Our Ref: R/124/20/NMA

Non material amendment following the grant of R/50/20/HH for the new ground floor front window re-positioned centrally & amendment to width of porch.

47 Priory Road Rustington BN16 3PZ

DRWG TITLE: **Proposed Elevations**
 DRWG No: **1034_301**
 REV: **C**

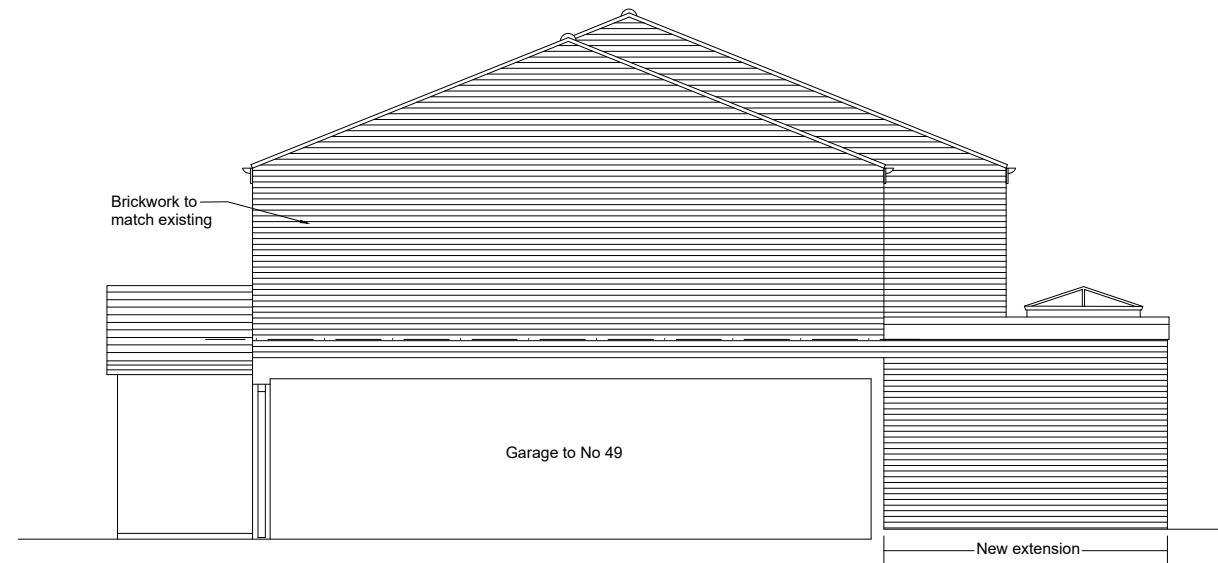
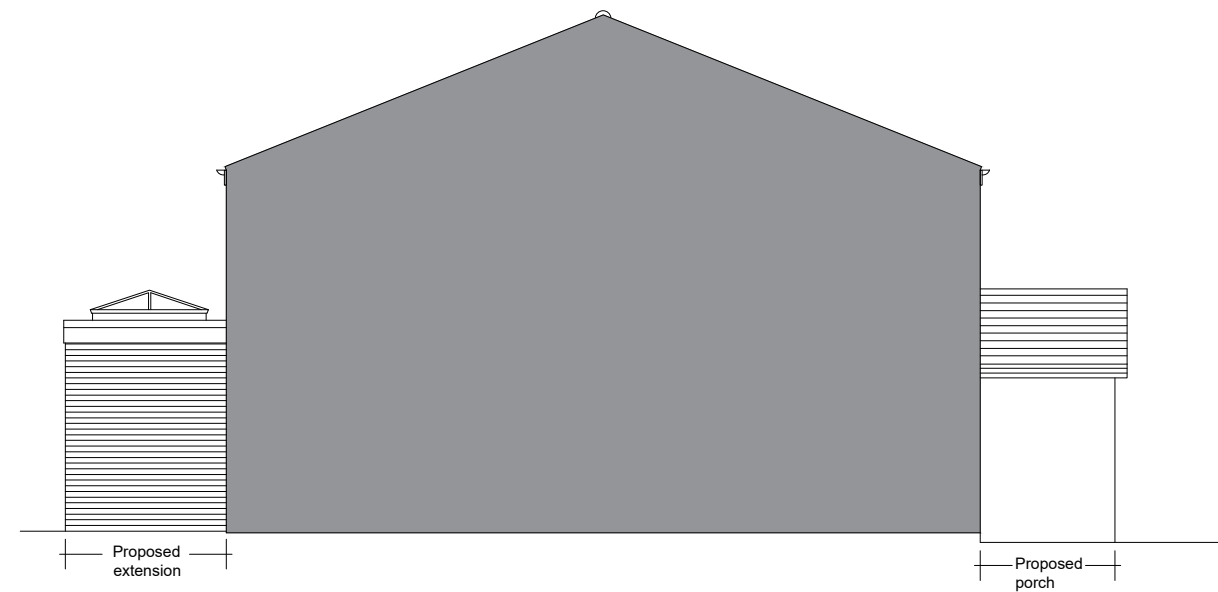
I refer to your recent application for a Non Material Minor Amendment. The proposal seeks to widen the porch by 0.27m, and amend the siting of the window by 0.45m.

Please note that plan references "Proposed site plan - 1034_101 - 05.03.20", "Proposed plans - 1017_201 - 24.02.20" and "Proposed Elevations - 1034_301 - 28.02.20 - Rev. A" are replaced by "proposed site plan - 1034_101 - 05.03.20", "Proposed Plans - 1017_201 - 24.02.20 - Rev. B" and "Proposed Elevations - 1034_301 - 28.02.20 - Rev. C".
